**From:** Edward Greenwood [REDACTED]  
**Sent:** 10 September 2014 11:21  
**To:** National Infrastructure Consents  
**Subject:** PREESALL UNDERGROUND GAS STORAGE FACILITY

Giles Scott Head of National Infrastructure Consents

Schematic layout of the Halite Energy Group Proposed Gas Storage Caverns at Preesall

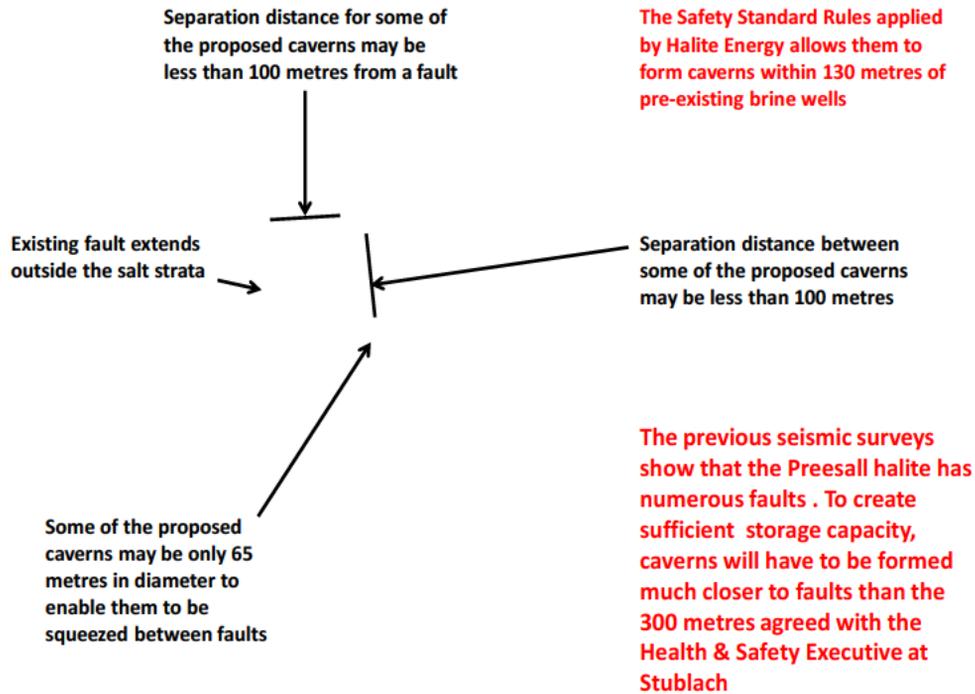
However, if my understanding is correct cavern 19 shown on the attached Halite drawing is too close to cavern 130 even to comply with Professor Rokahr's standards.

The Rokahr Rules state - "The distance between pre-existing caverns, brine well, water and gas wells that are sufficiently deep to potentially impact new cavern integrity, shafts and other man made subsurface features and wet rockhead should be at least 4 times the MAXIMUM cavern radius". **On the basis that cavern 130 is 100m diameter it should be at least 200m from cavern No19 not 150m which would be the case if the Halite drawing is correct.**
